## EL PASO COUNTY GRADING AND EROSION CONTROL PLAN CHECKLIST

Sheet No.: _____ 2

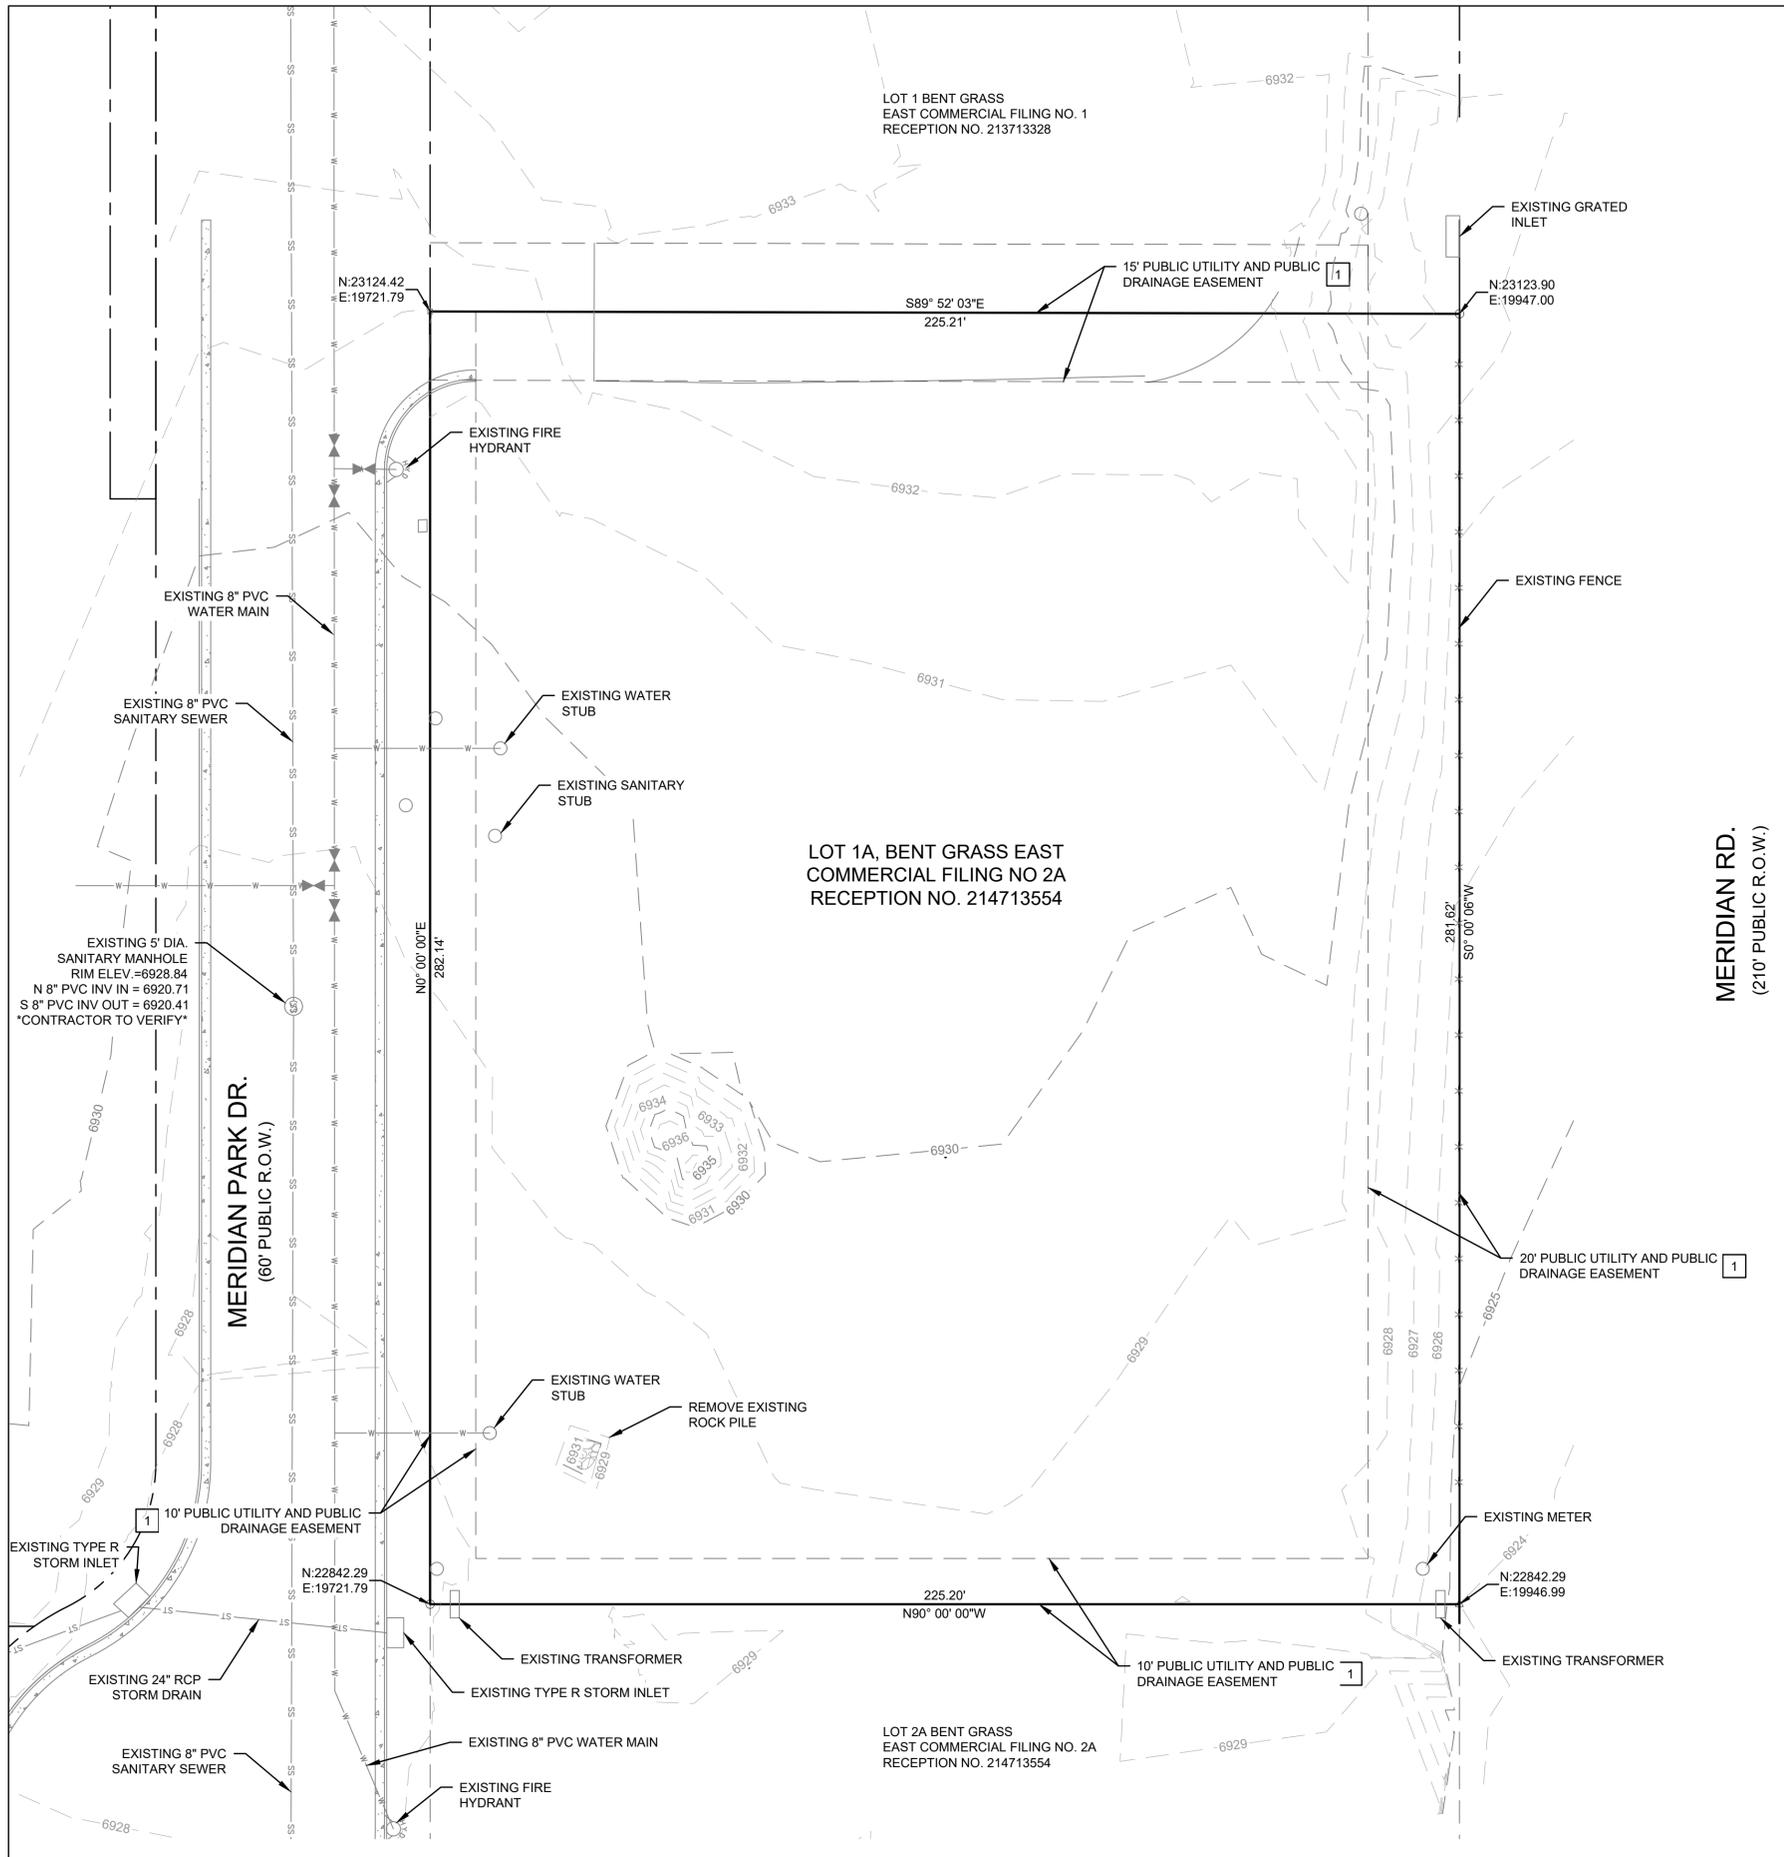
The GEC was submitted as a standalone doc so revise the signature blocks on sheet 2 to match those highlighted above.
